CITY OF ALBUQUERQUE

August 8, 2007

Re: Mesa Del Sol Elevated Water Reservoir Grading and Drainage Plan
Engineer's Stamp dated 7-24-07 (R16/DA3004)

Re: Mesa Del Sol Elevated Water Tank Grading and Drainage Plan
Engineer's Stamp dated 7-9-07 (R16/D096)

CITY PROJECT NO. **R-16-Z** SHEET **5A** OF **5**

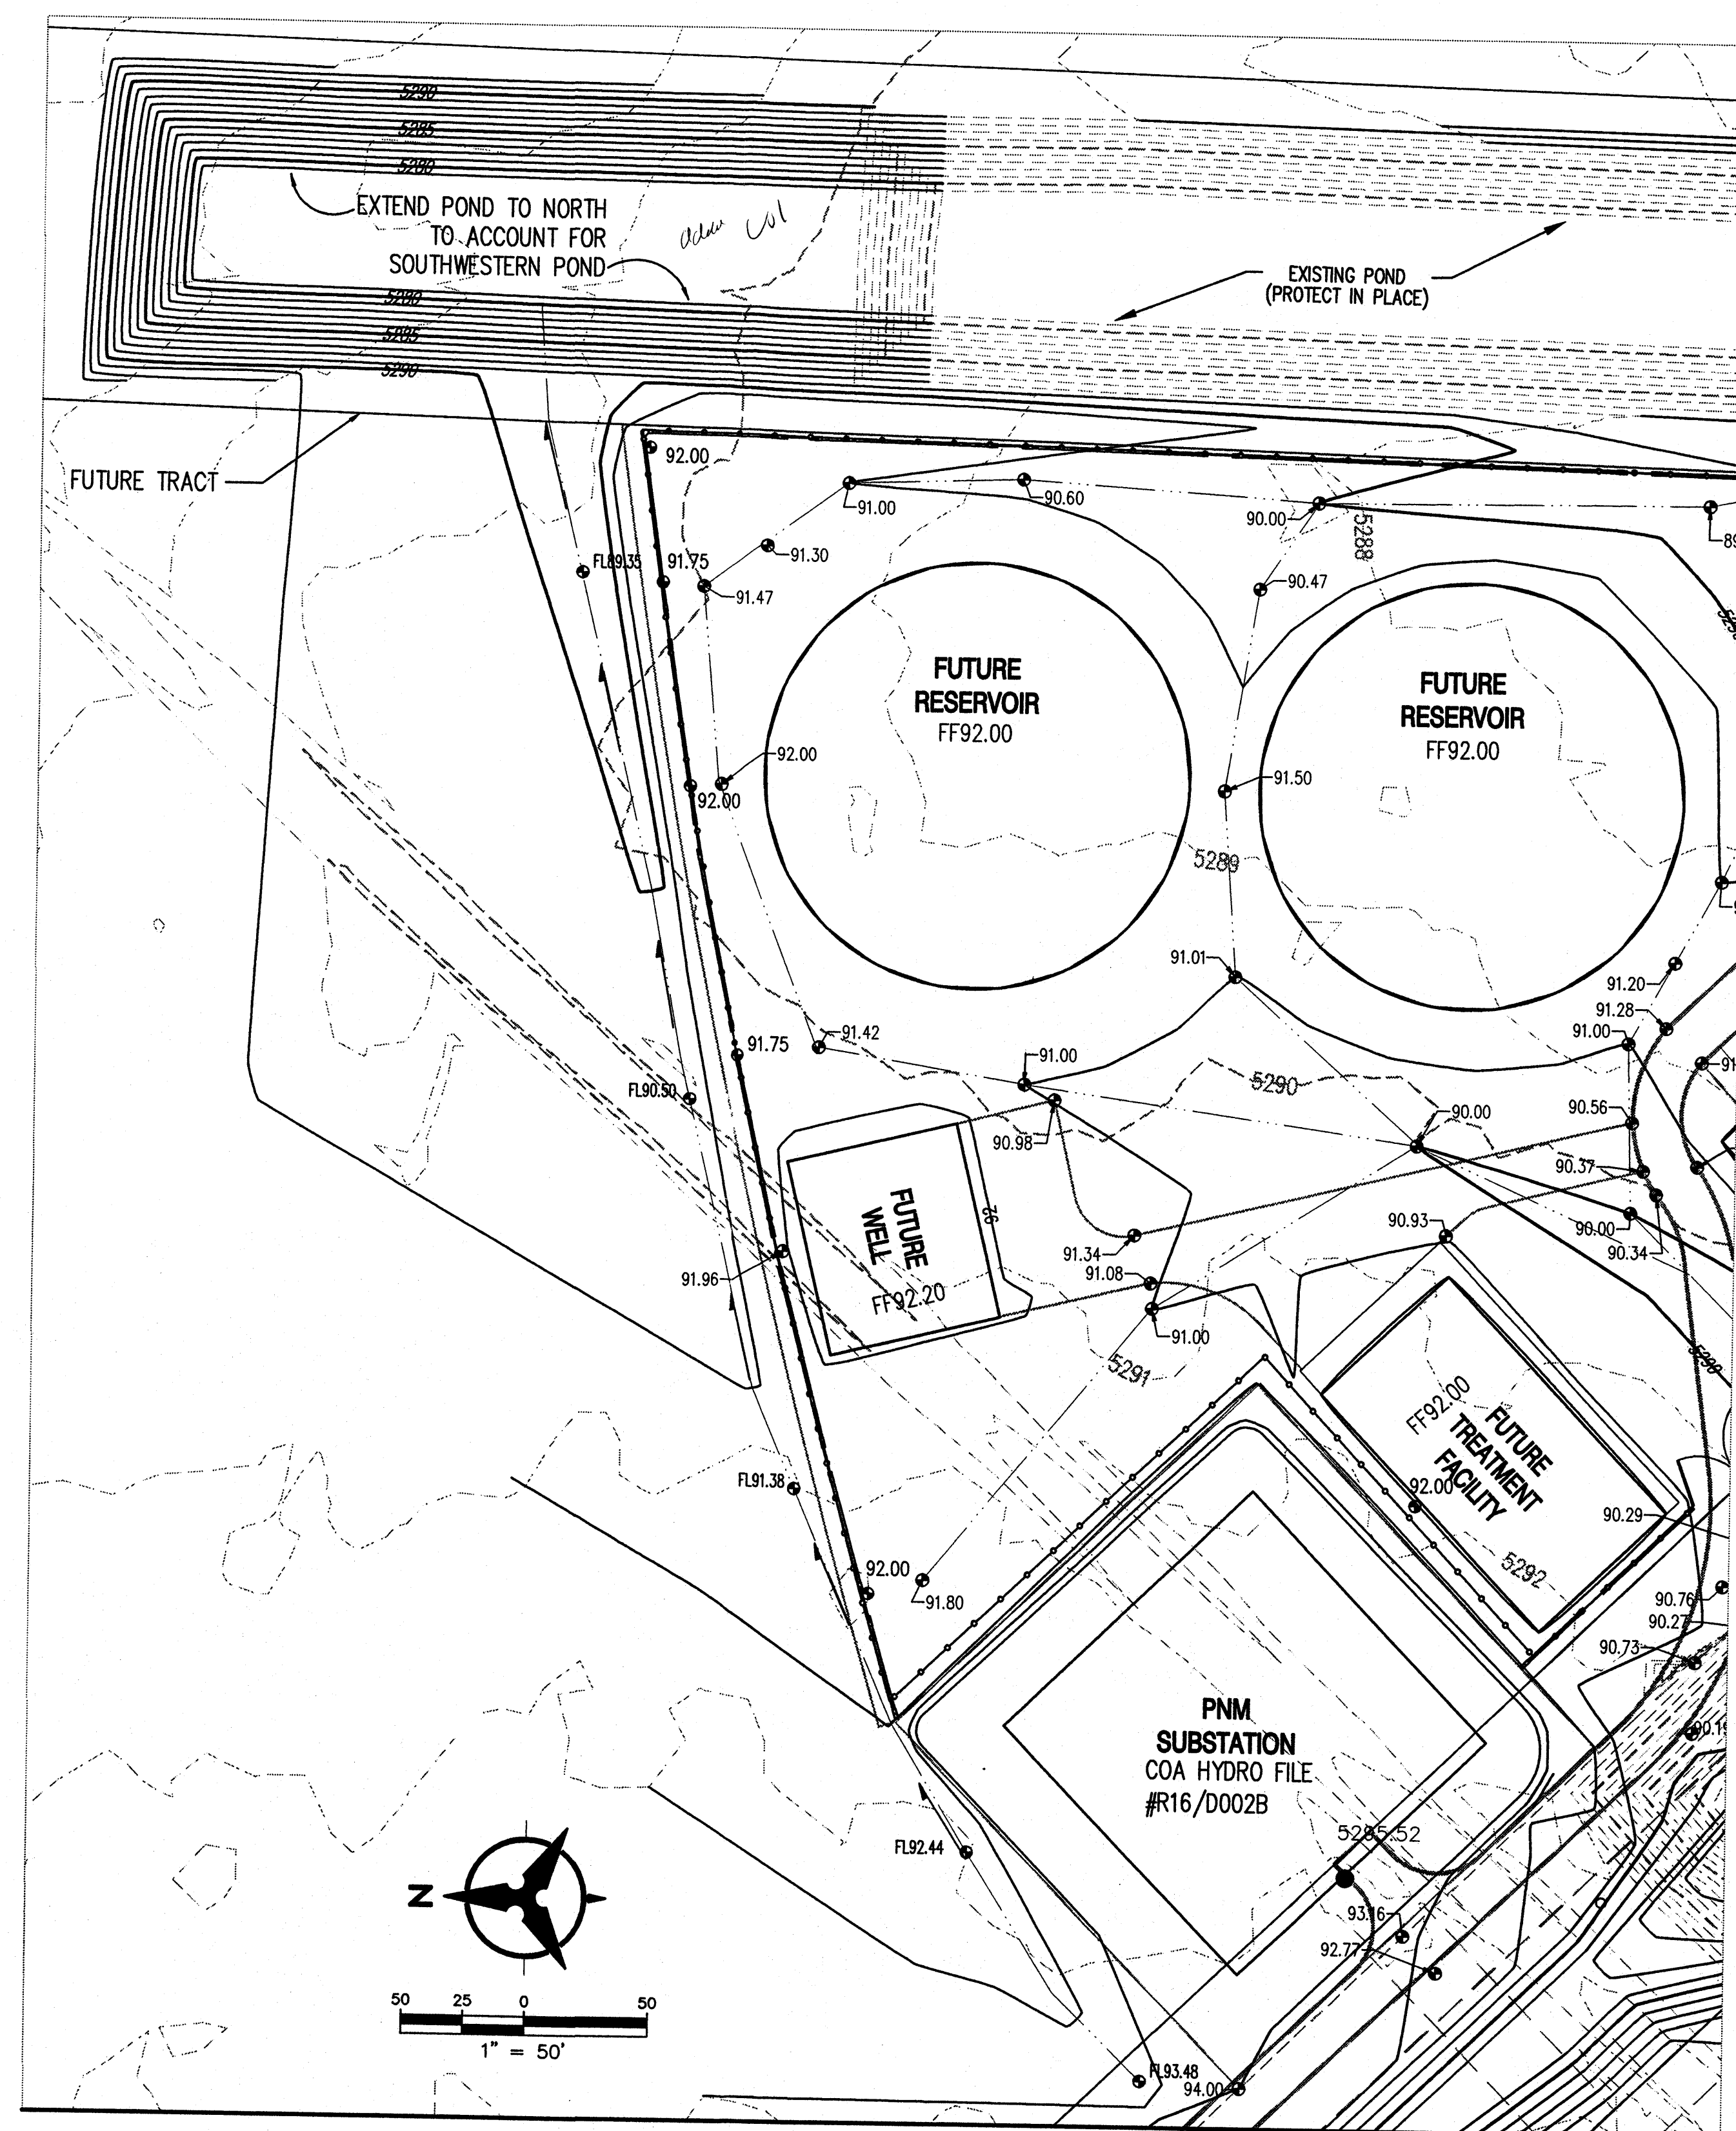
- The Site Access Plan shows the access road in the bottom of the swale leading to the regional pond, while the grading plan shows the access road on the east shoulder of the swale. The location east of the swale is preferable. The Site Access Plan also shows the power pole in the drainage tract, whereas the Grading Plan depicts it outside of the drainage tract.
- The access road in the drainage tract should be maintained by PNM/ABCWAU. A maintenance agreement is required.

- More information is required before the ponds can be graded and related infrastructure can be built.
 - Inverts are required for the 2-36" RCP storm drain connecting the two ponds. In addition show the pipe ends in both ponds.
 - Which COA STD SPEC are you planning on using for the Rip Rap rundowns? What is Type VL? Is "1" thick" a typo?
 - Provide an invert for the rundown into the south pond.
 - Provide new volumes of the two ponds.
- It appears that grading of the site is integral with grading of the ponds and since more information is required before grading the ponds, the site should not be graded until approval is given to grade the ponds.

1. The access road to the site has been revised on all sheets. The access road is currently located east of the trail. In addition the power pole has been shown correctly on the Site Access Plan. The Grading Plan shows this pole in the correct location.
2. A maintenance agreement will be obtained by PNM/ABCWAU for the access road.
3. Inverts for the 2-36" RCP storm drain connecting the regional retention pond together was provided.
4. The rip rap specification call-out was revised and corrected.
5. An invert for the rundown in the south pond was provided.
6. Volumes for the design volume required and the volume provided have been shown on sheet
